TREE WORK ASSESSMENT

TPO: 213 - 2019 The Land at Whalley Road, Barrow, Clitheroe

APPLICATION NO: 3/2026/0594

HORSE  
CHESTNUT TREE

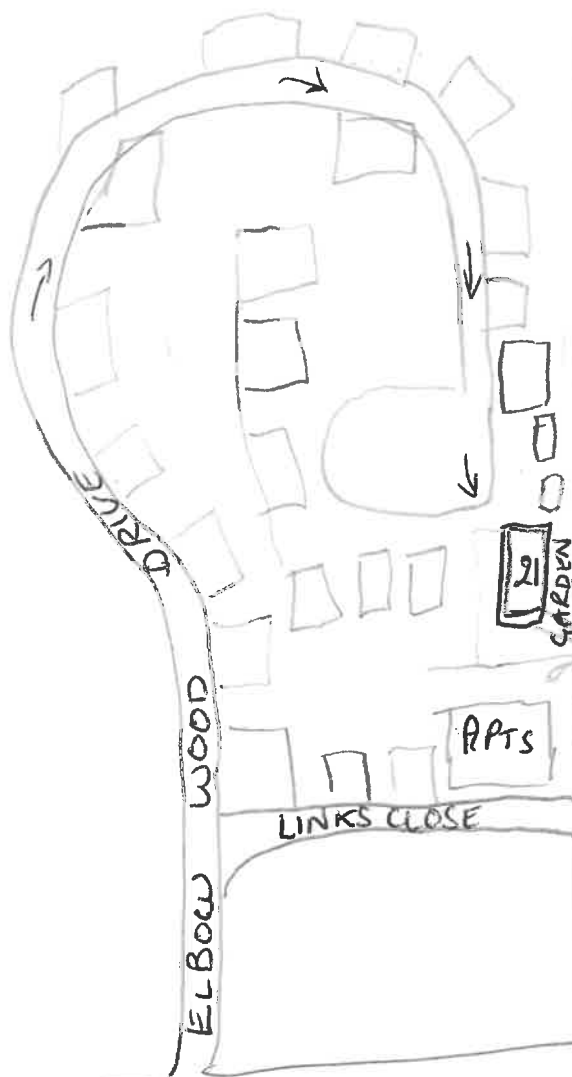
T1 is still of amenity value, however T1 has shed some large limbs in recent storms and requires the crown to be rebalanced which can be achieved in part by reducing the weight in the limbs overhanging the applicants garden but the landowner should have the whole tree and crown inspected when carrying out these approved works to minimise the risk of future failures.

Due to historic failures and the target range increasing due to development T1 requires some pruning to help rebalance the crown and minimise future failure.

T1 requires a full tree health survey and an ariel inspection is advised when the contractor is carrying out the approved works. It is advised the contractor to inform the Council when the works are being carried out in case any further pruning works are required.
